Date 10th December 2020

RE: Butlins Upper Bognor Road Bognor Regis PO21 1JJ

Thank you for your correspondence of the 8th of December 2020, advising me of a planning application for Erection of temporary buildings to accommodate performance stage and seating for a period of up to 3 years. This site is in CIL Zone 4 (Zero Rated) as other development at the above location, for which you seek advice from a crime prevention viewpoint.

Diagram 4 : WC's and Bar area

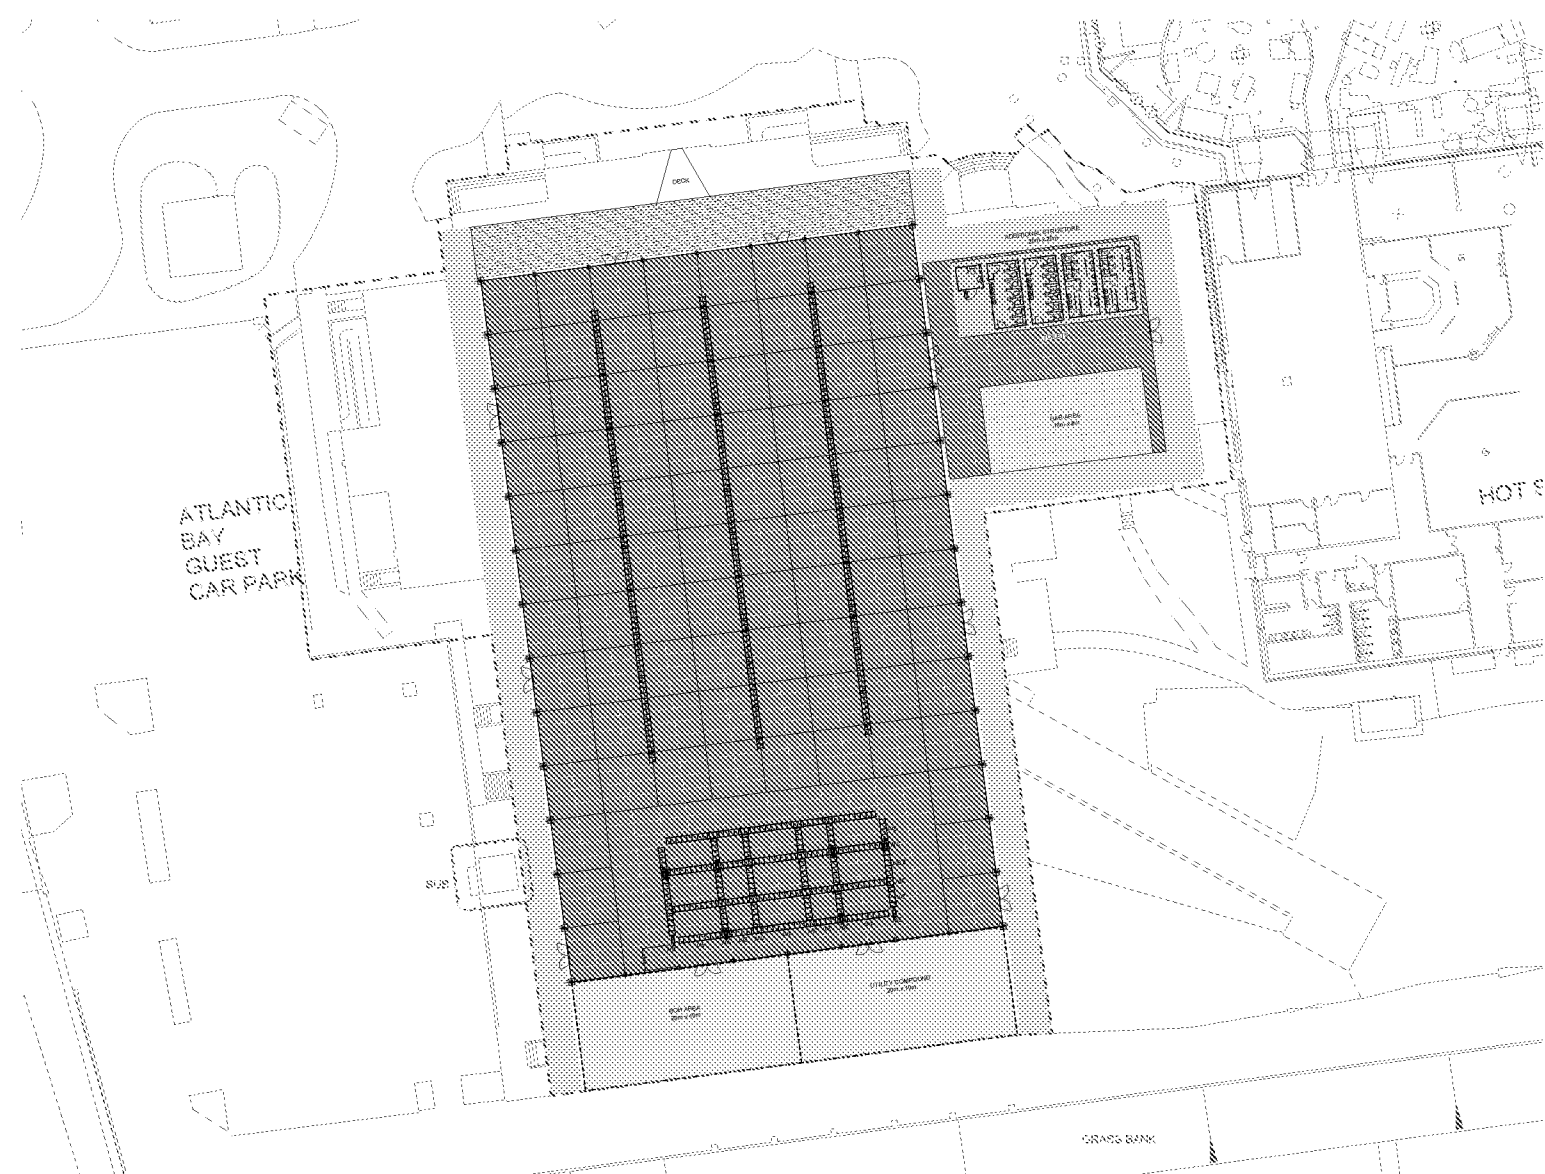
With regards to the bar area the applicant and their partners are strongly advised consult directly with Police Licensing at Sussex Police before making plans for licensed premises serving alcohol or conducting other licensable activities at this site.

From a crime prevention perspective in relation to the bar area thought should be given to alcohol only being bought onto the site when performances are occurring and not being stored permanently in situ. Failing this thought should be given to locking alcohol away and consideration given to the siting of CCTV and an intruder alarm to reduce potential incidents of theft.
